From: campb@fairpoint.net
Sent: Wednesday, April 16, 2014 12:01 PM
To: Lindsey Ozbolt
Subject: Kachess Shoreline setback (SV-14-00001)

Sheet Title
SITE PLAN
SCHEMATIC

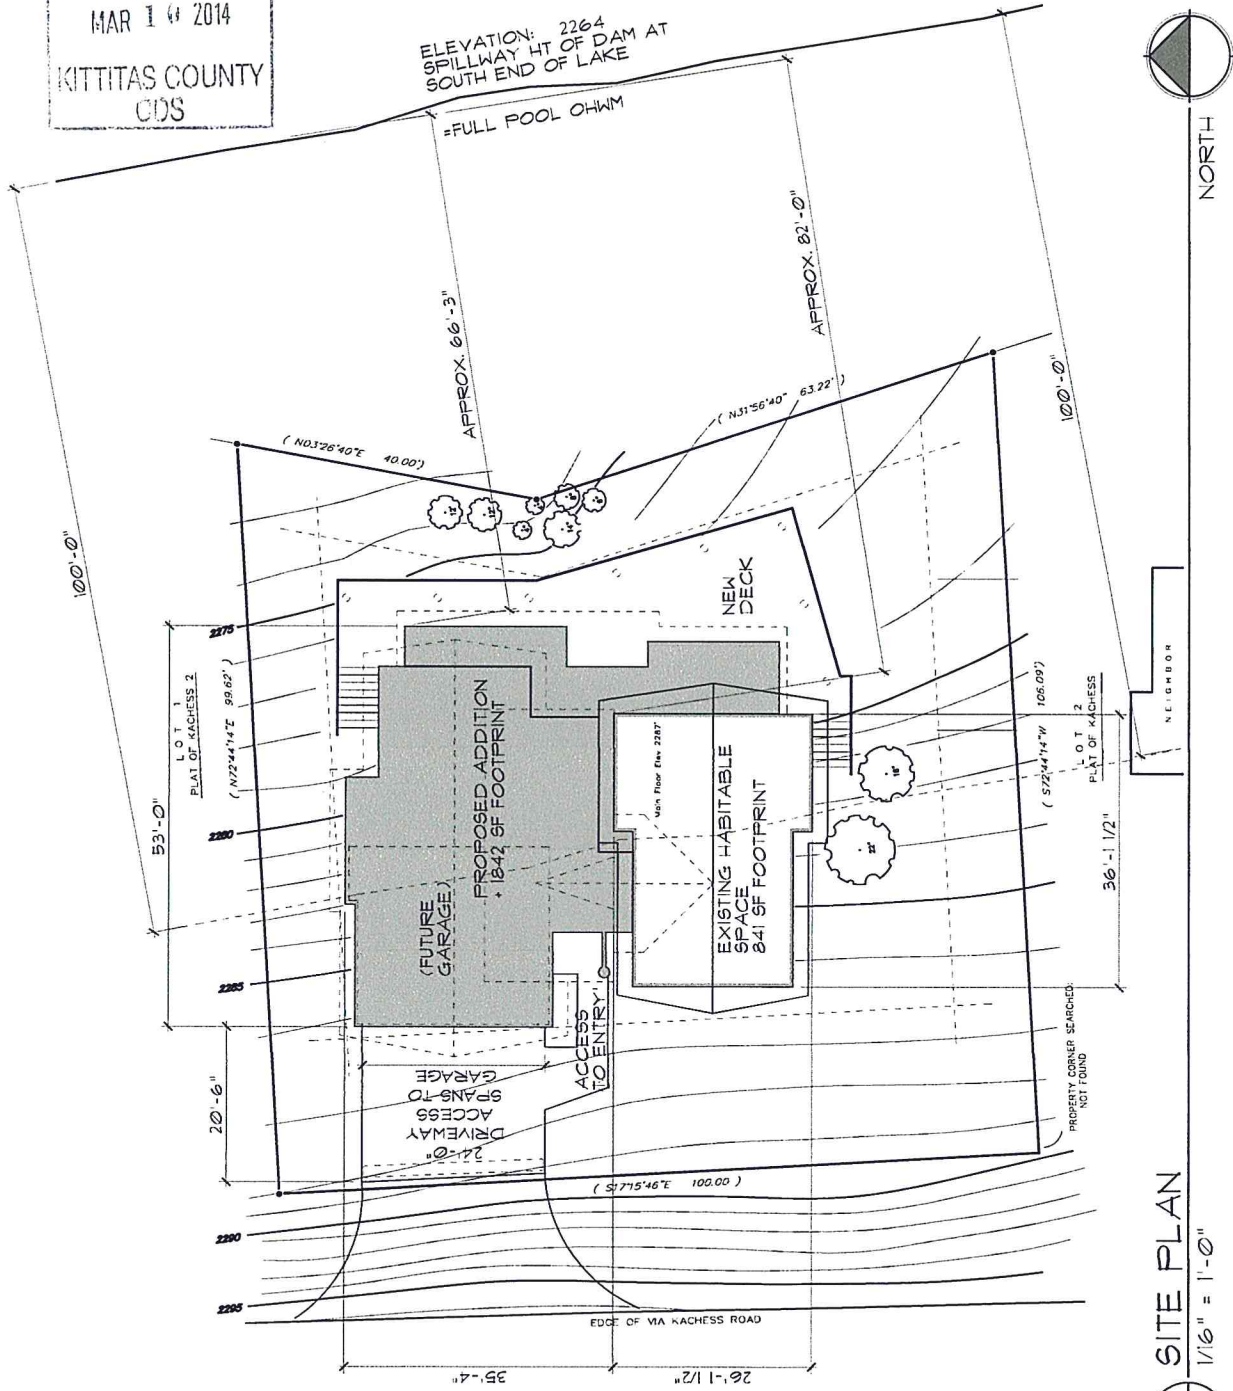
1. Appears you did not realize that the US Government owns land, managed by the United States Forest Service (USFS), between the ordinary high water level (OHWM) and the original take line. The Bu of Reclamation manages all lands up to the OHWM . The data on Lake Cle Elum shows this type of ownership. but it is not shown on your Lake Kachess map data.
The request could affect the US Government owned lands, managed by the USFS, or be in violation of required setbacks from property lines. Property corners were all in place about 20 years ago- not sure now- but it needs to be addressed for allowable setbacks from other property ownership. An educated guess would be that the applicant property line is the Government land boundary, which puts the proposal very close to the property line.
